Engineers Comments Regarding Surface Water Drainage

Application Reference:	WA/105/25/PL	Reviewer Reference:	ADC/EXT5/AF
Planning Officer:	Kathryn Welch	Date of Review:	12/01/2025
Site Name:	Cherry Tree Nursery Eastergate Lane Walberton BN18 0BA		
Application Description:	Removal of residential caravan and erection of 1 No. self build dwelling (resubmission of WA/52/25/PL). This application is a Departure from the Development Plan and is in CIL Zone 3 and is CIL Liable as a new dwelling.		
Assessment Number:	1

PL300

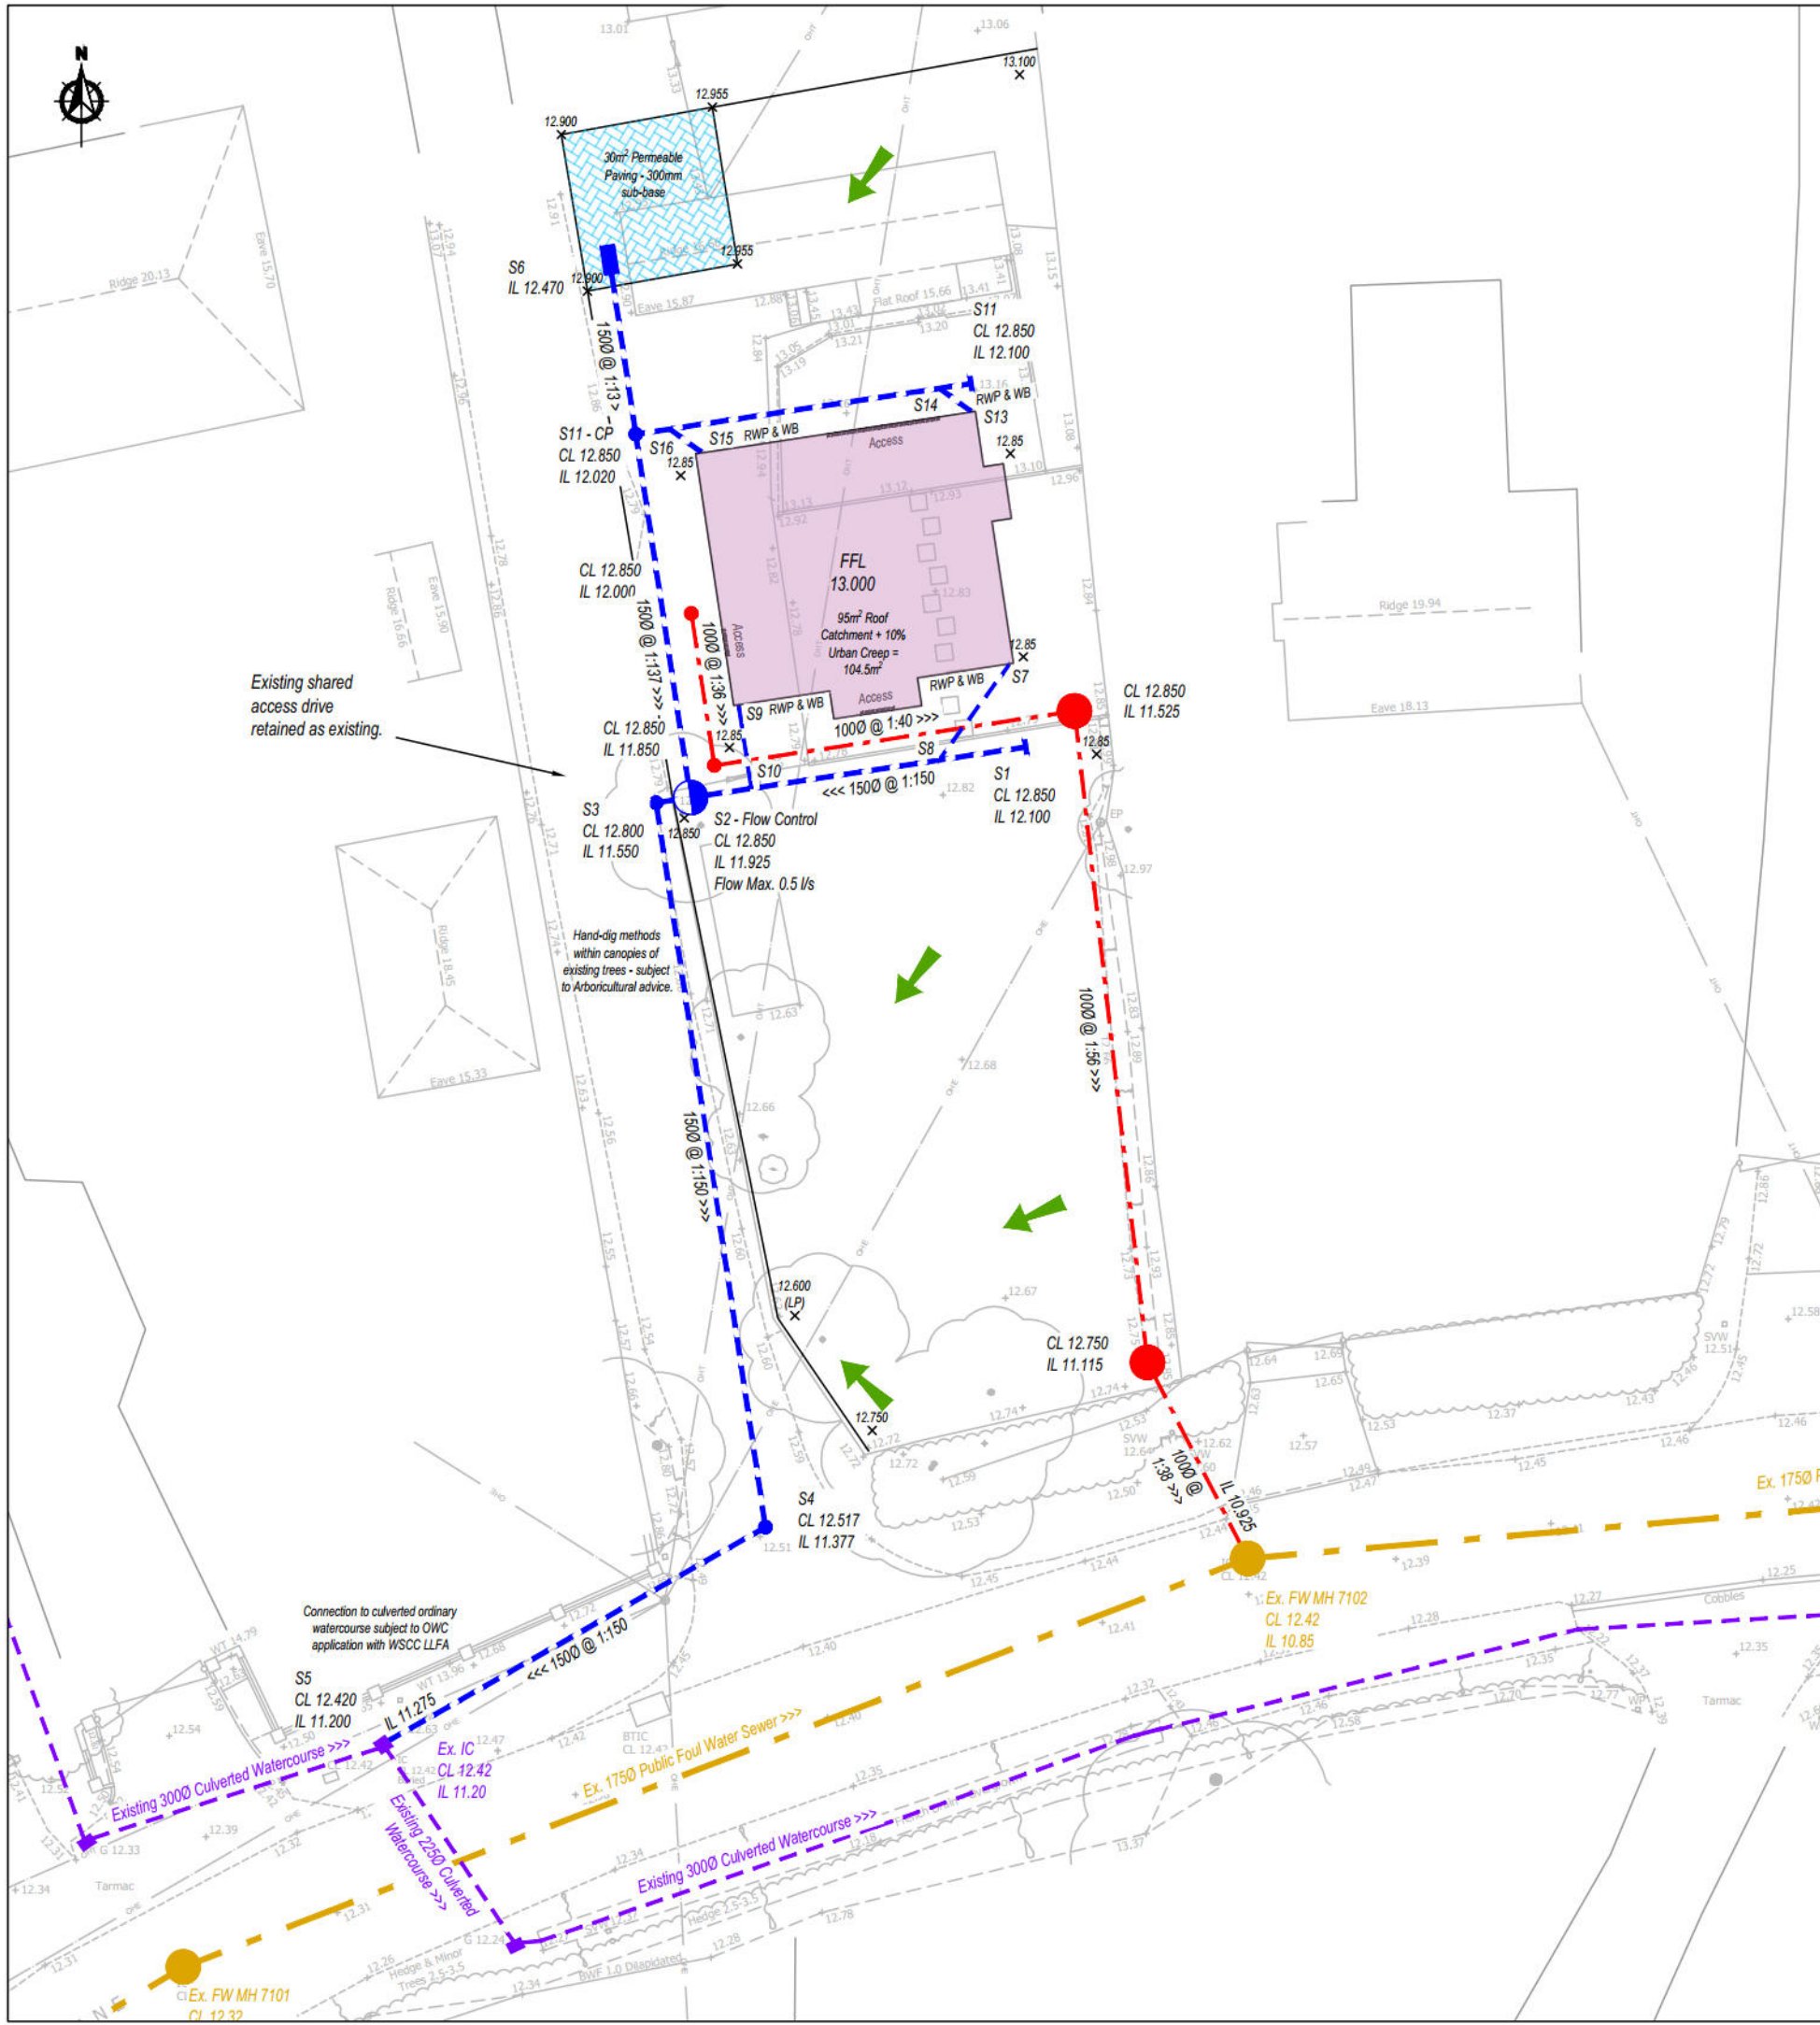
- 1.3. The outlet drain appears to cross third party land and the applicant should provide evidence of legal ability to install the drain and discharge surface water to the watercourse.

- 3.1. The design flow restriction is based upon 0.5 litres per second which is a significant increase on the greenfield runoff rates for the drained area of 0.03 l/s. The NSfS states a multiple of 5 times GFR for the 50% AEP and 1% AEP storm should be considered the maximum for brownfield sites. The applicant should investigate restricting the peak runoff to 5 times GFR or as close as practicable using appropriate modern flow control devices and blockage protection for source control.

- 3.2. As the existing shared driveway may not drain satisfactorily and may therefore produce runoff which enters the drainage system, the area which would drain onto the drained area of the development site should be included within the calculations.

- 3.3. The flow control chamber currently appears to be within a root protection zone and whilst there is a note requiring hand digging within canopies, the location may not be feasible unless confirmed by an arboricultural assessment.

- 3.4. The exceedance flow paths do not appear to include the permeable paving and access road.
- 3.5. Management of extreme rainfall is not currently in accordance with the requirements of the NSfS (Standard 3). Therefore, we **object** to the application.
